From: Nicola Spencer on behalf of Planning.Responses
Sent: 09 February 2018 13:53
To: Karen Garner
Subject: FW: 93 Middleton Road application numbers M/123/17/HH and M/133/17/HH PL
Attachments: Site and Block Plan Middleton Road V5.pdf; 93 middleton existing elevations.05.12.2017.pdf; Middleton Rd AB 100 7E Version5 08.02.2018.pdf; Middleton Rd AB 100 11C Version5 08.02.2018.pdf; Middleton Rd AB 100 12 Version 5 08.02.2018.pdf

Dear Mrs Gardner, As agreed at our meeting on Wednesday 7th Feb, I have modified the drawings as discussed and included the additional items covered in my email dated the same day.

To address your design concerns, I have modified the original scheme shown on applications numbers M/123/17/HH and M/133/17/HH in the following aspects:

SECTION E:E

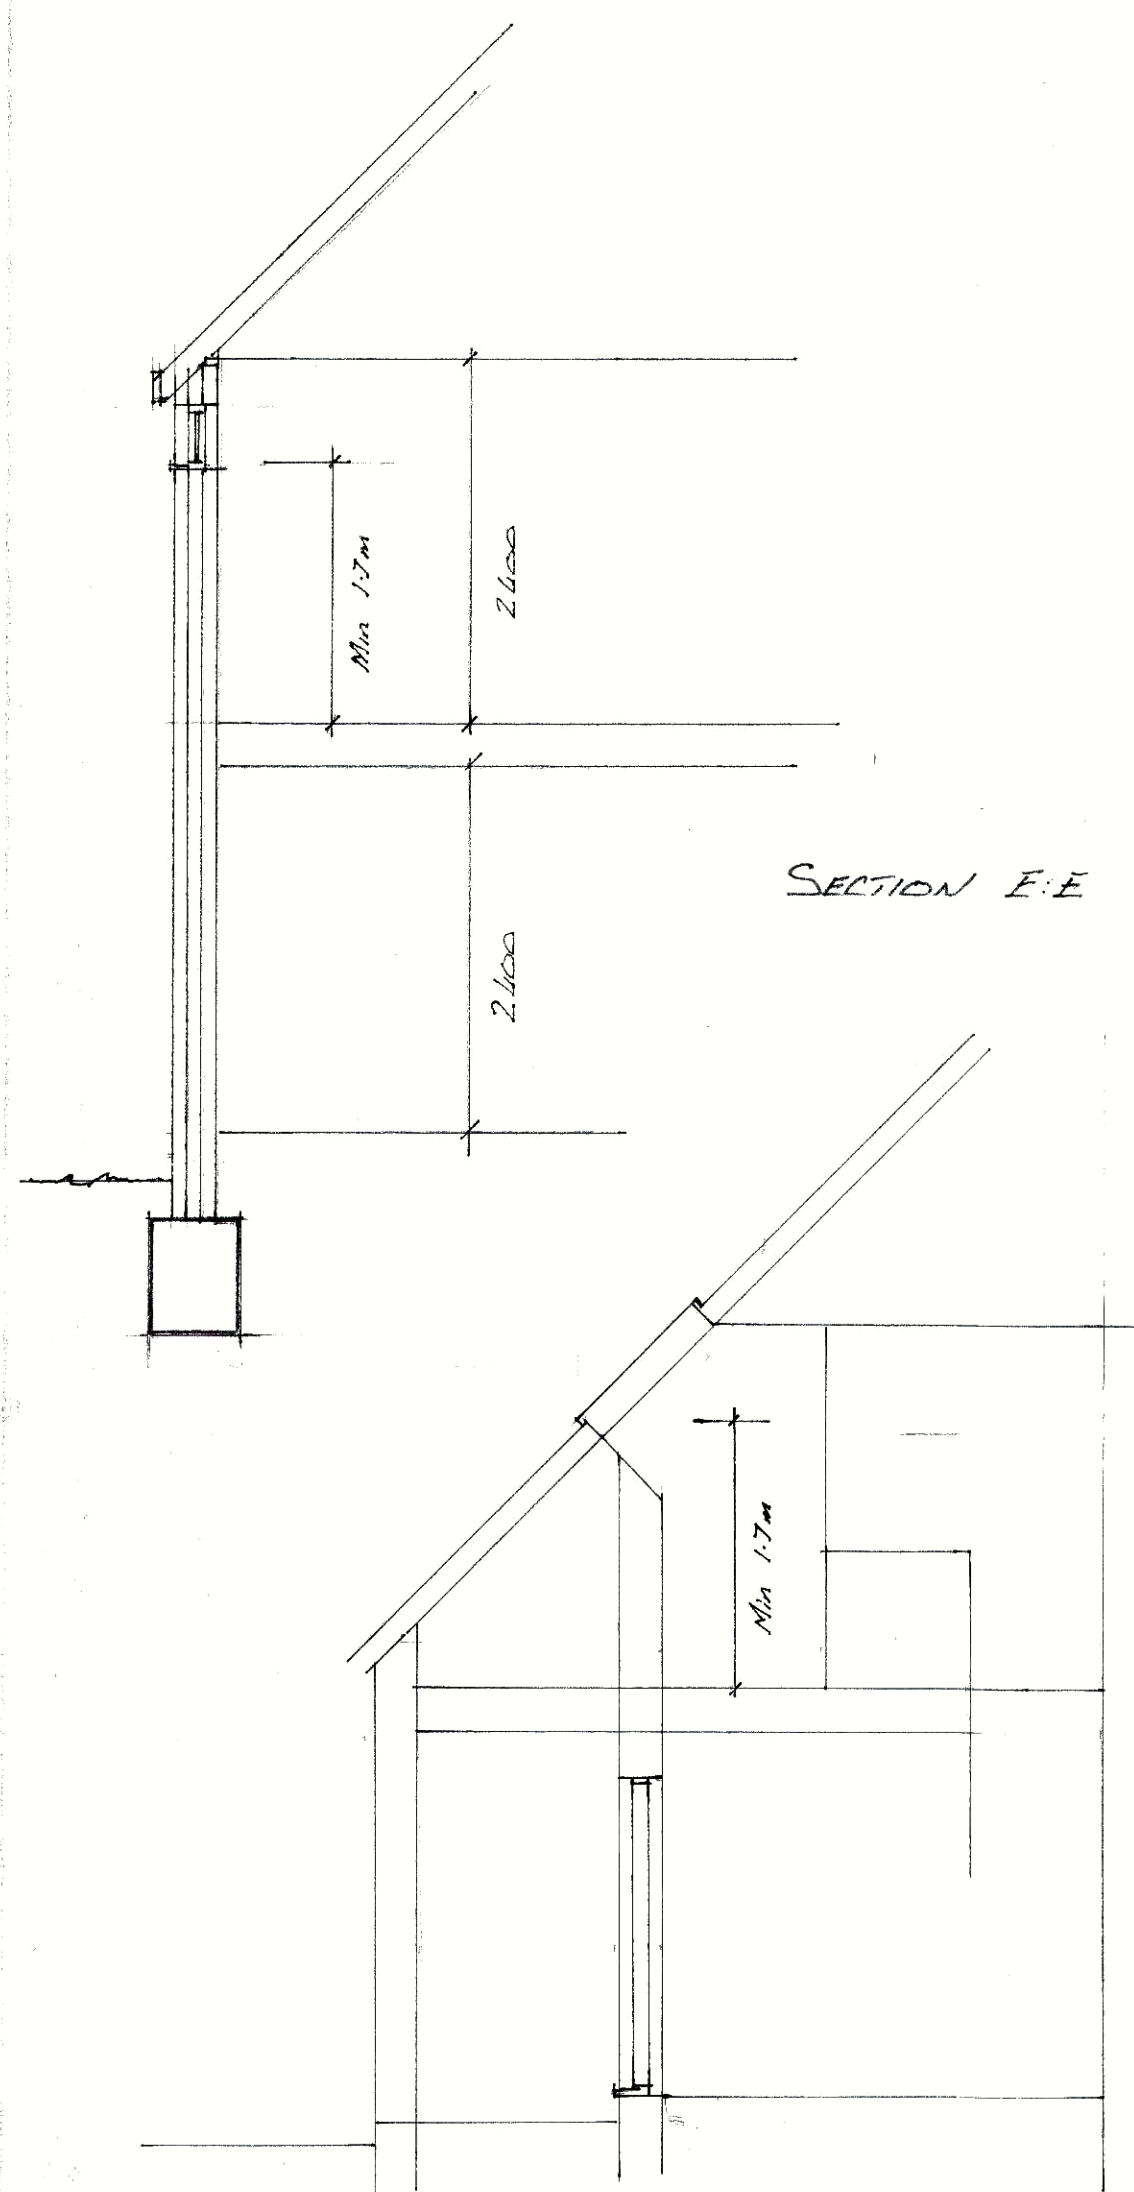
1. Moving the bulk of the extension to the front of the property predominantly on the south west side of the existing building.
2. Removing the cat-slide roof feature shown on the east elevation of the previous scheme
3. Reducing the ridge height on the east side of the building from that shown on the previous scheme
4. Only having one high level window on the east elevation (see section E on drg no AB 100 11C)

DRC N°: AB: 100 12

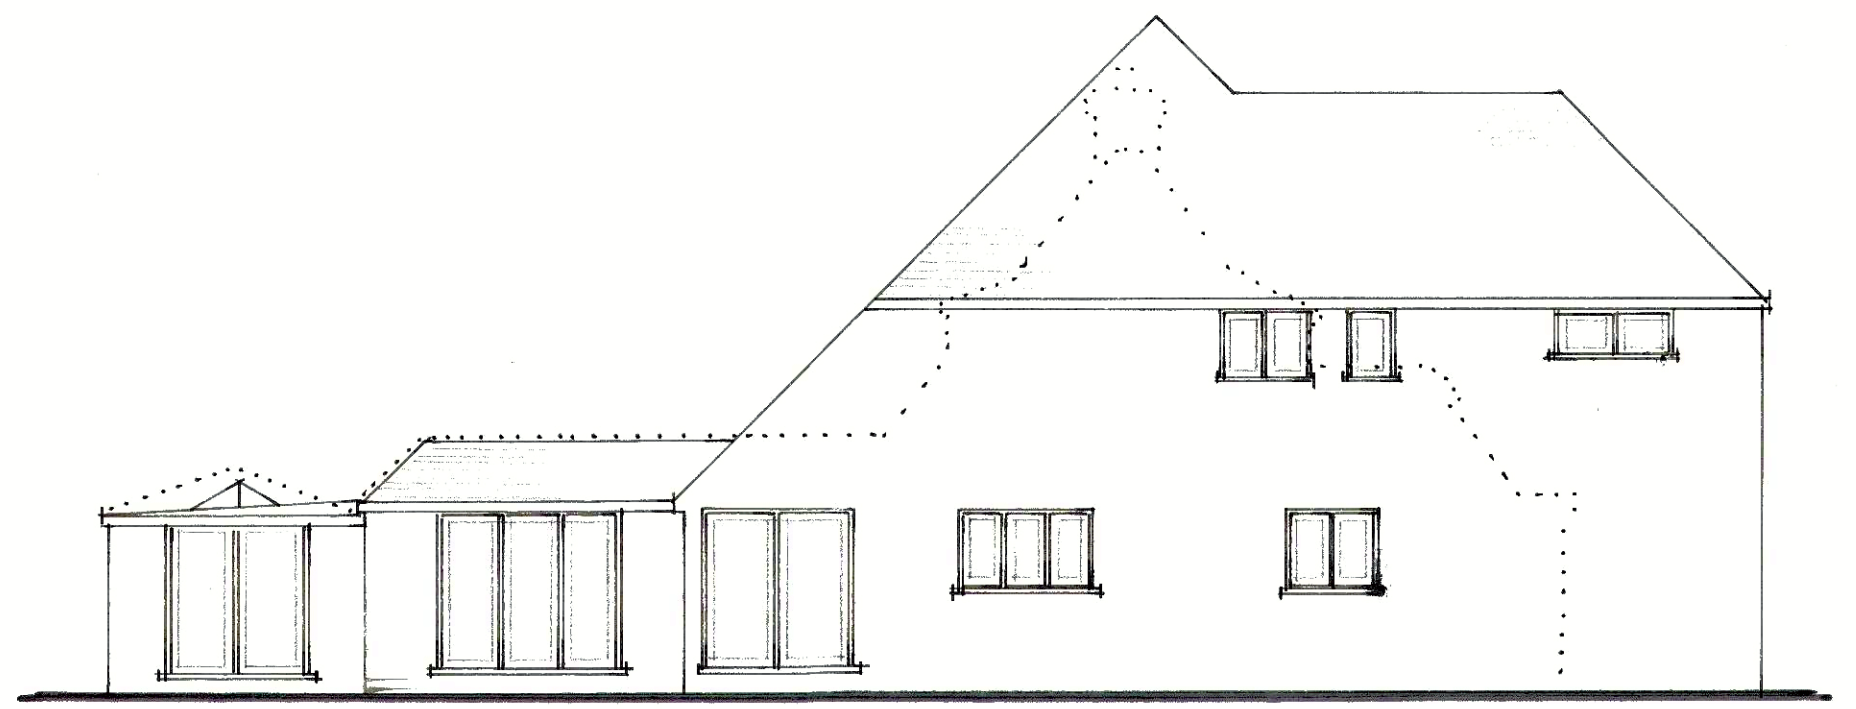
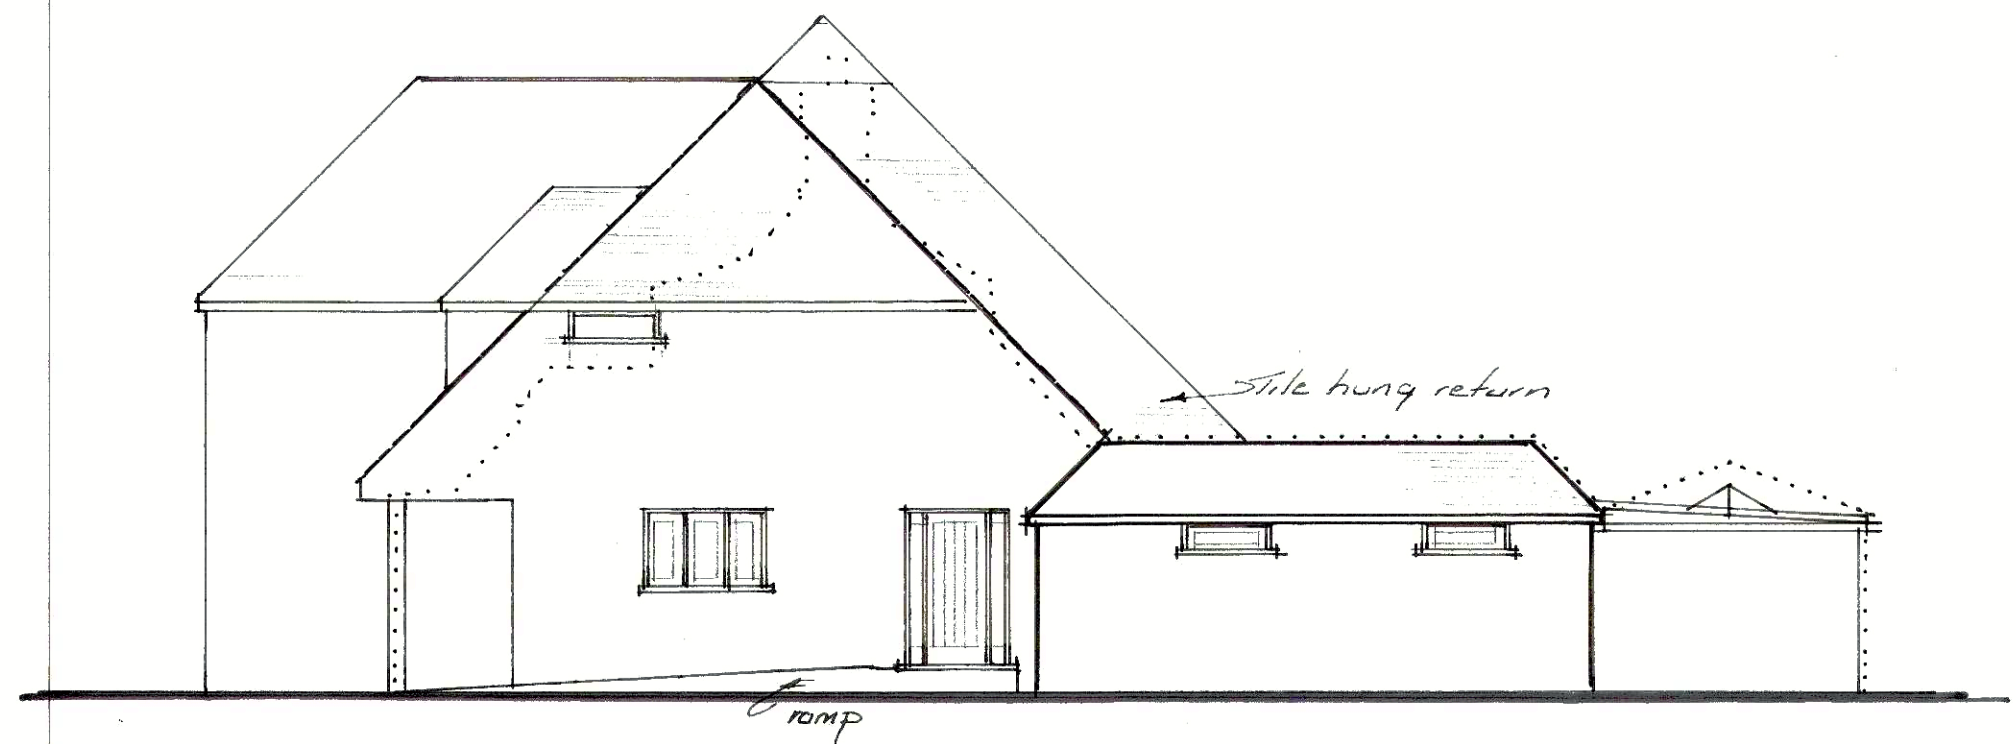
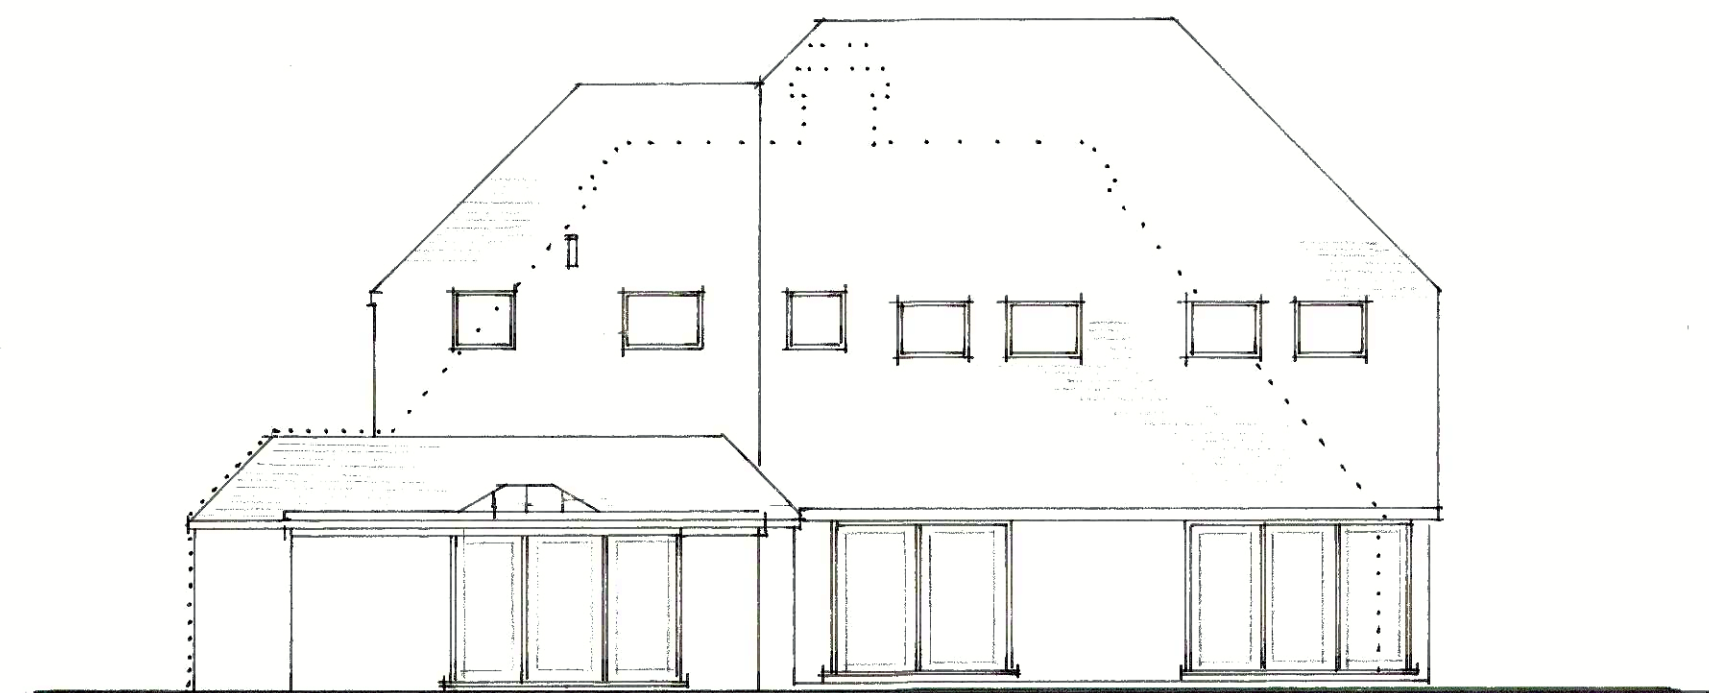
12. I have dotted the existing building outline on drawing number AB 100 12
13. To assist with your review of the street scene, I will send another email with photo shots of the adjoining properties.
